October 19, 2022

RE: Panda Express – S8-22-D8582  
10126 Coors Blvd. NW  
Albuquerque, NM 87114  
RE: DRB Planning Review – 4<sup>th</sup> Resubmittal  
DRB Project Number: 2022-006547  
App. Number: SI-2022-00216  
Delta 4 response

- Heights Venture is providing a response to your comments in the statement below. Our responses are in **RED**.
- TRM engineering response to comments are submitted separately attached to this submittal.

C01.0

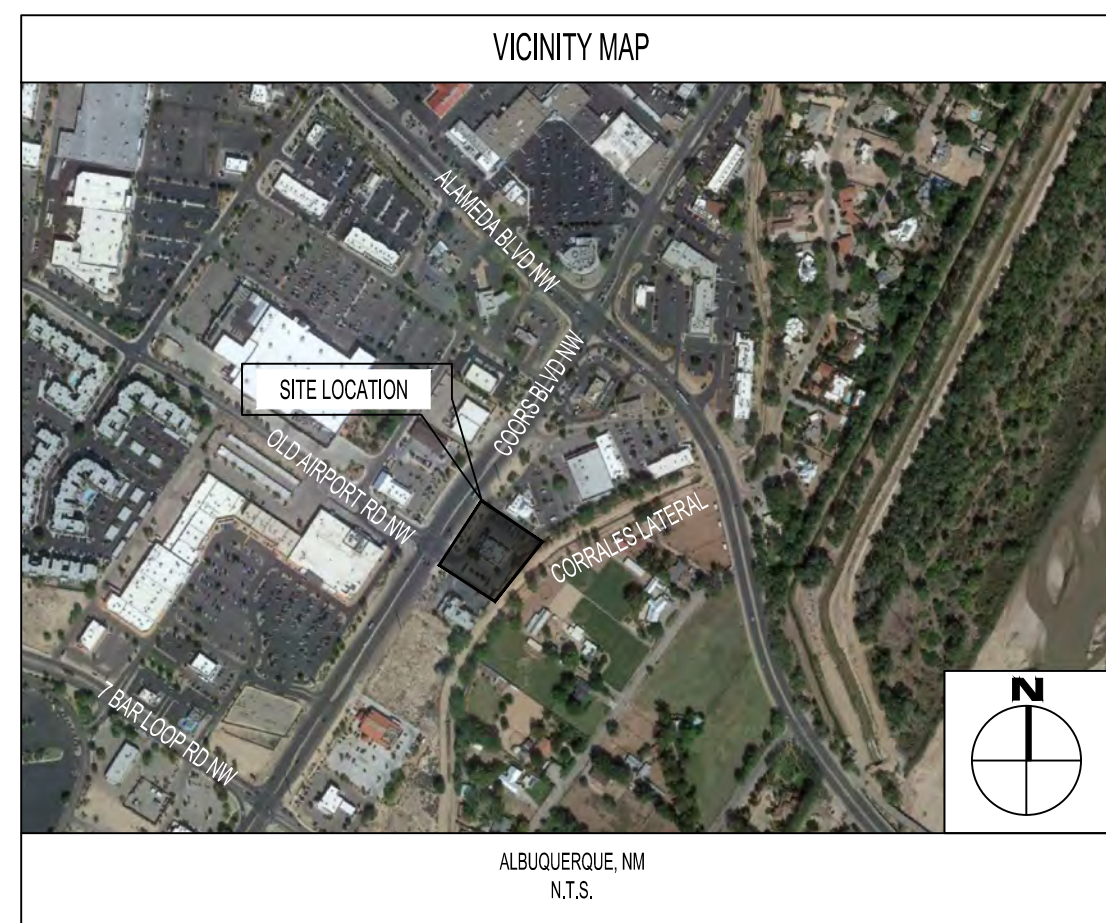
**Response:** *Please reference to RTM engineering response.*
- Due to the amount of work that NMDOT is requesting, a COA work order is needed and this shall also be added to note #6 on C01.0.

C03.0

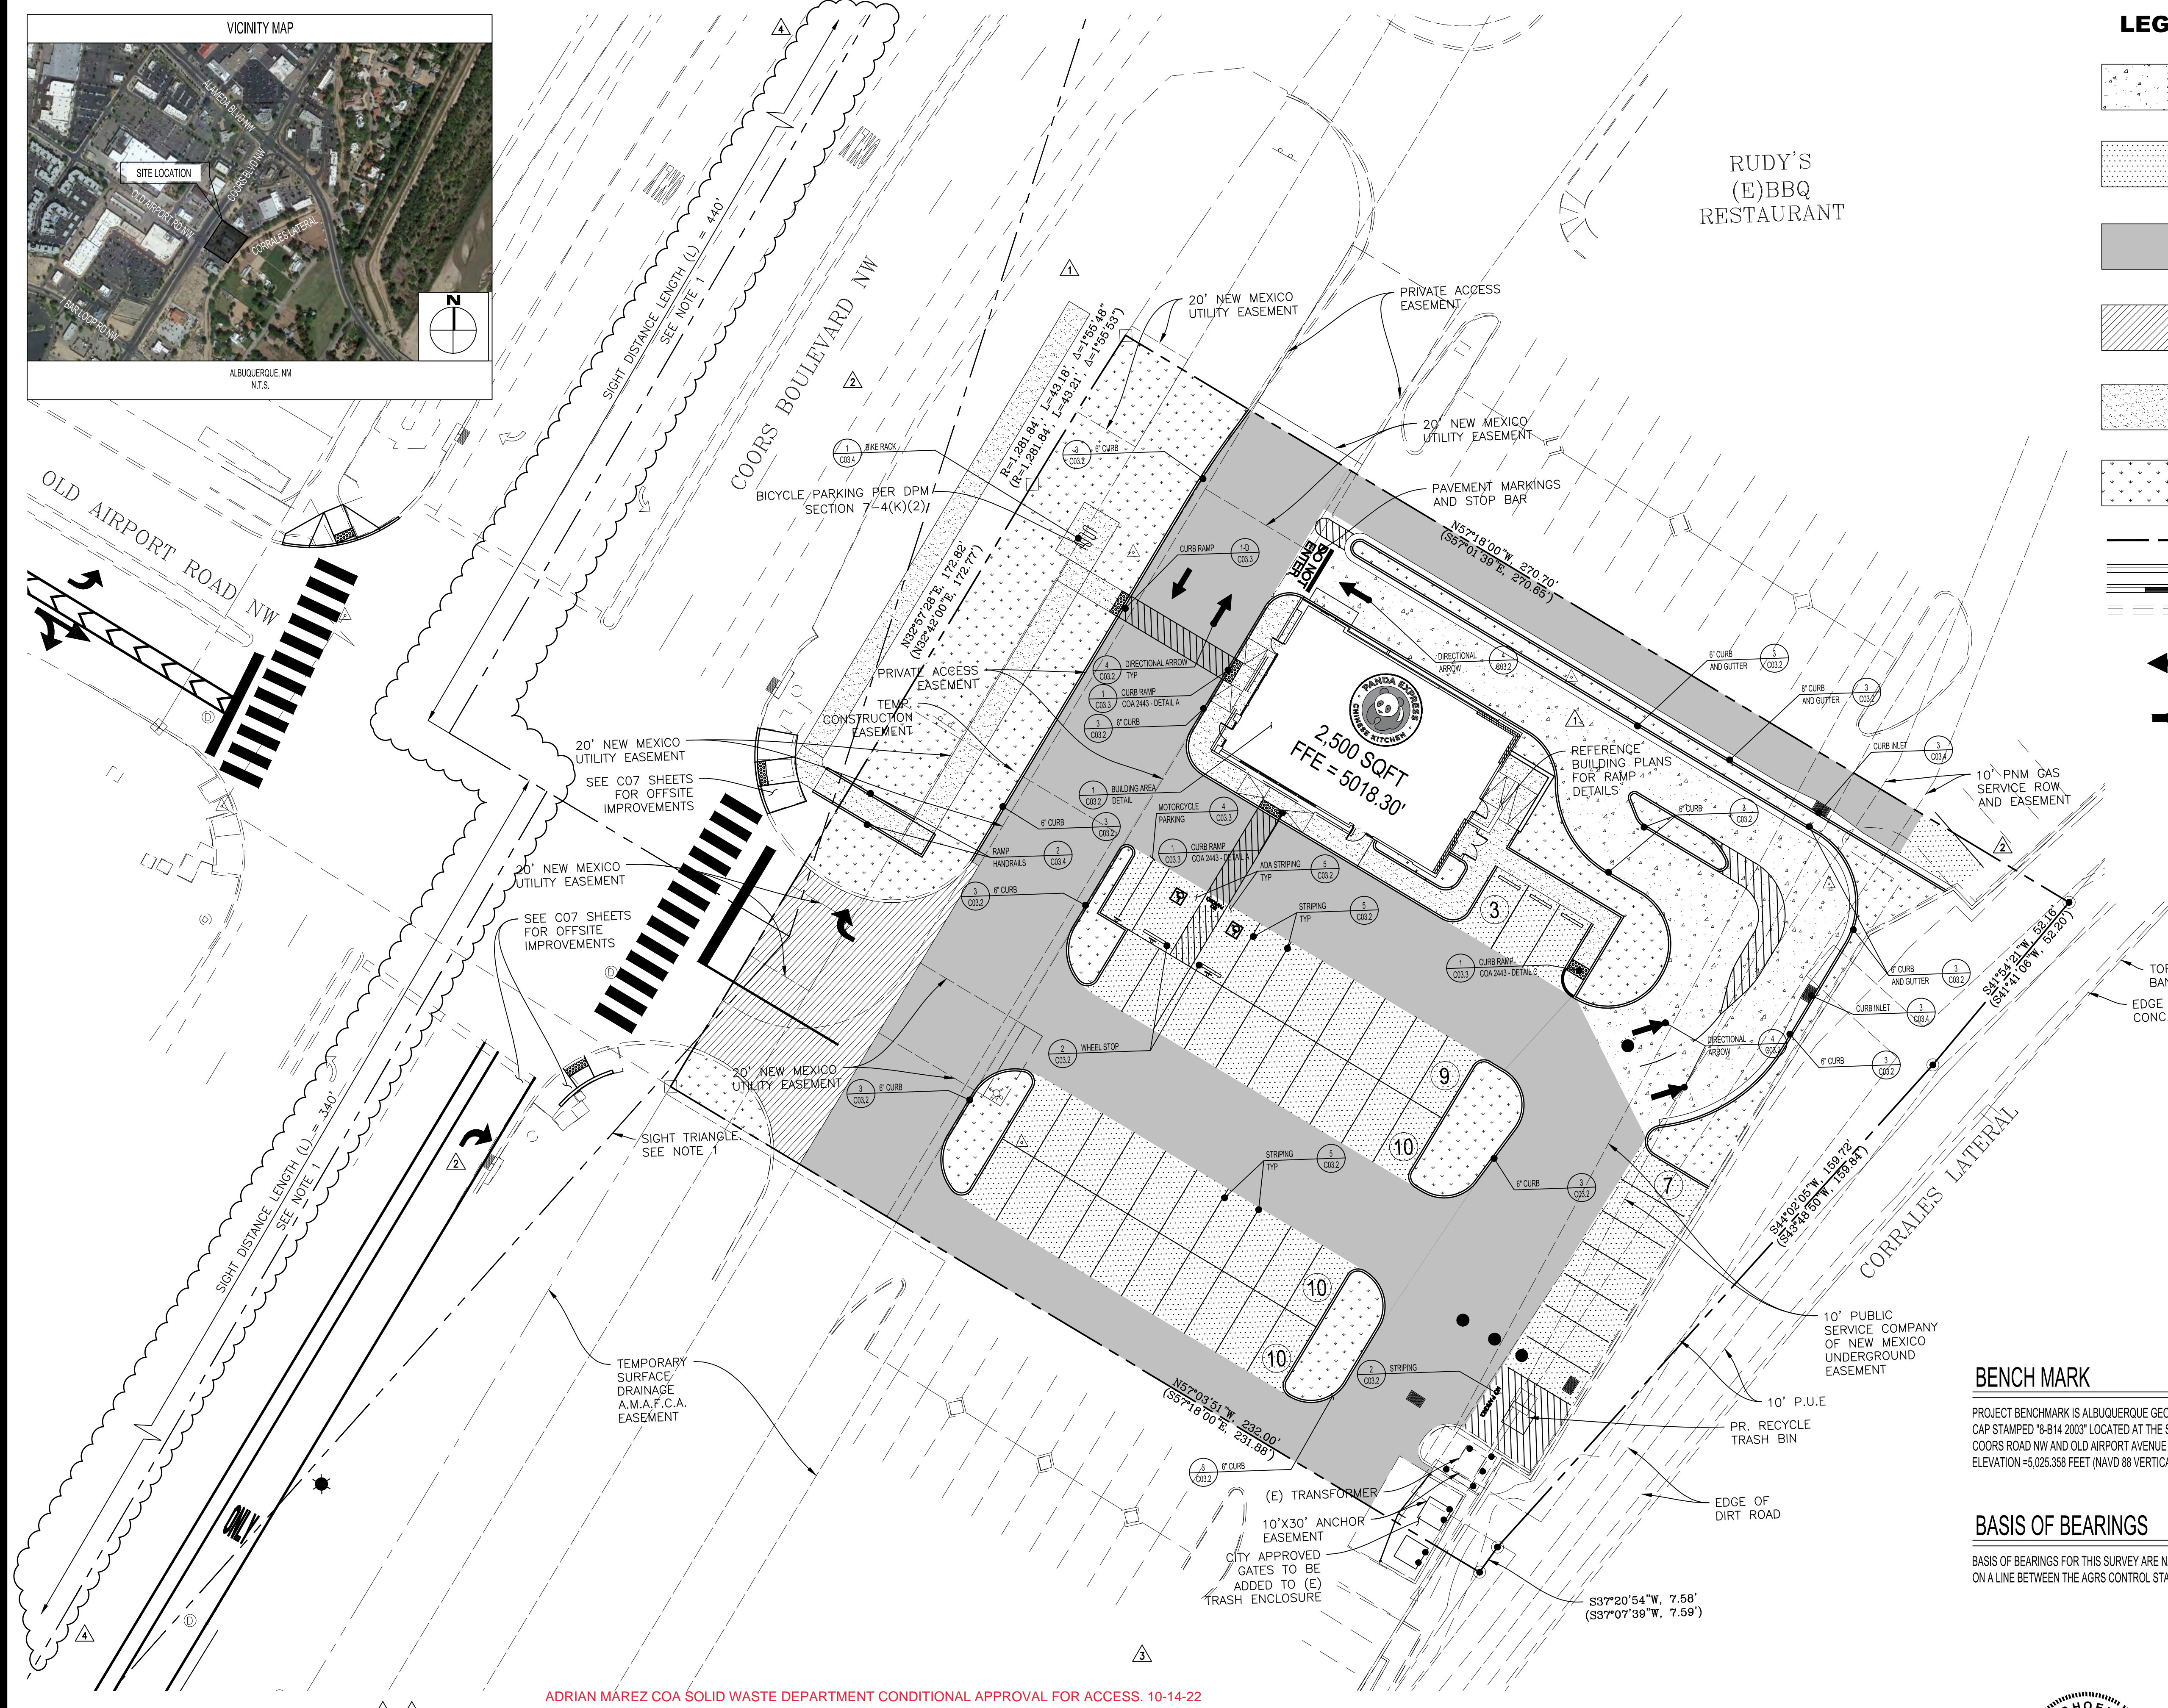
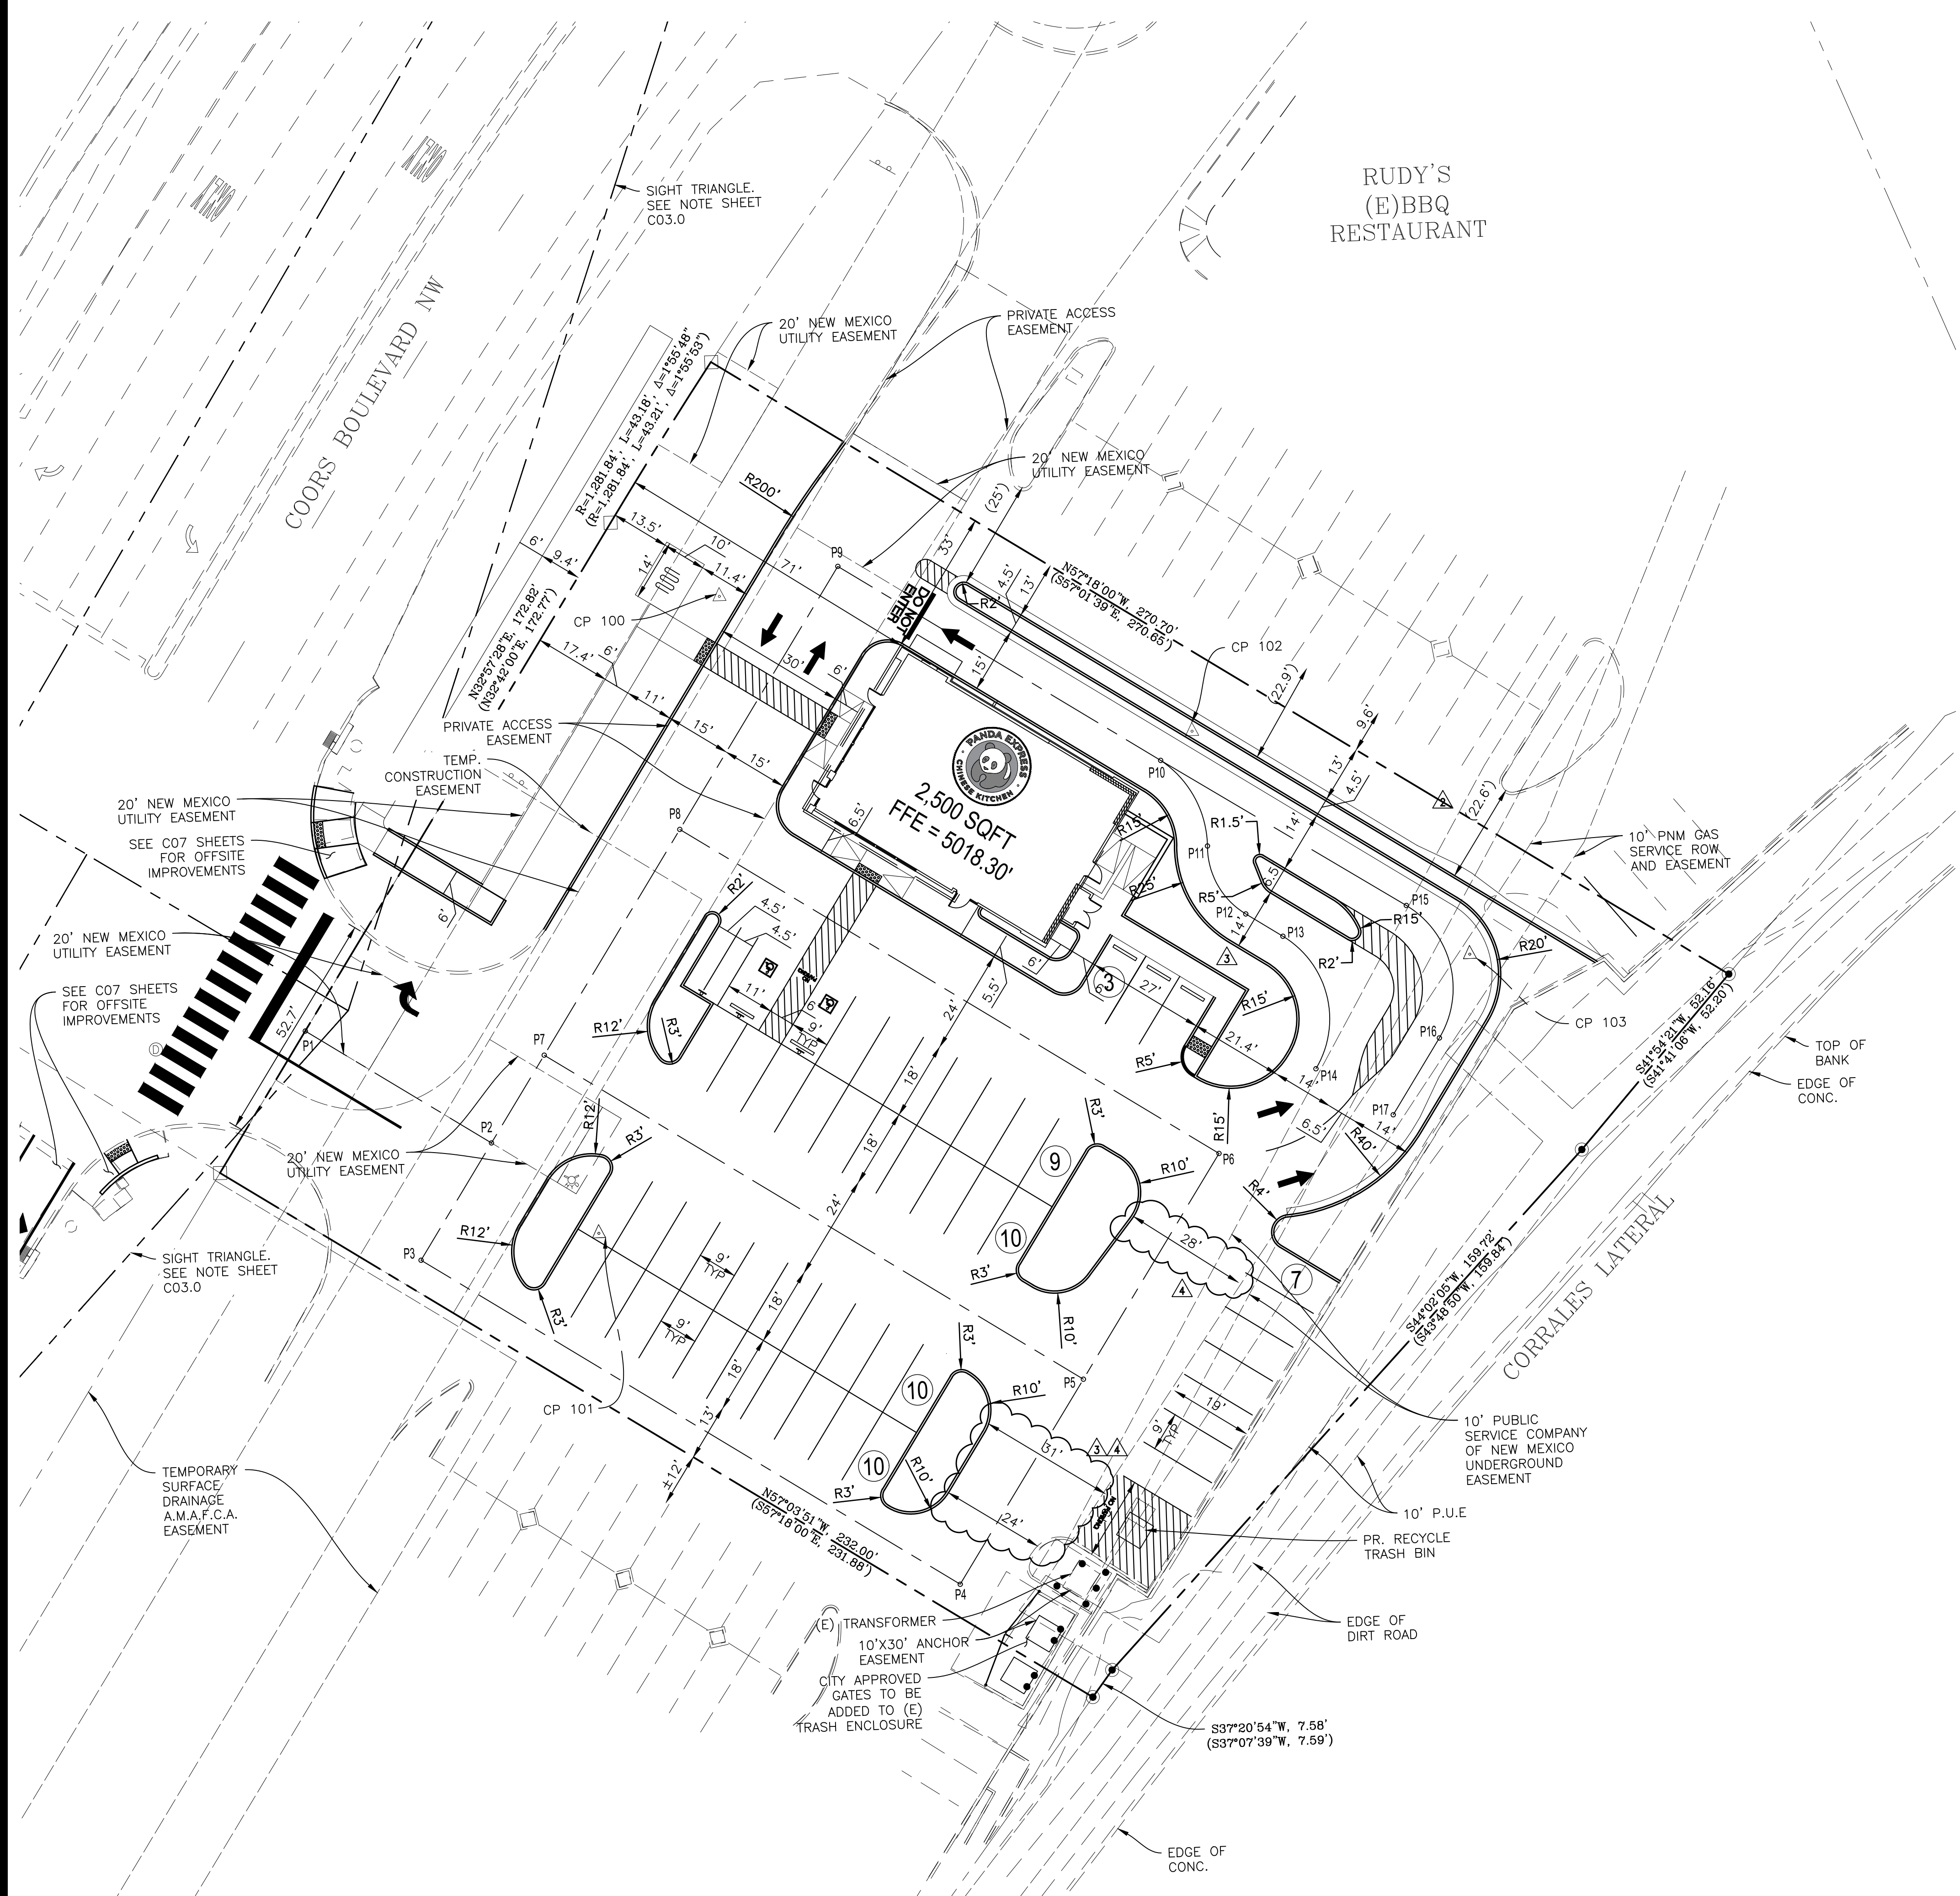
**Response:** *Please reference to RTM engineering response.*
- Include the driving aisle width along the east side of the site. It is called out as "Varies", so please call out width at various critical points on the site plan.

**Response:** *Please reference to RTM engineering response.*
- The clear intersection sight distance triangles shown at the entrance appear to be based on driveway clear sight and not intersection sight distance. Please use intersection on sight distance shown in the new DPM Chapter 7 page 7-114.

**Response:** *Please reference revised site plan, sheet A-100 and Planting plan, sheet L-1. Also, please reference RTM engineering, civil drawing, C03.0.*
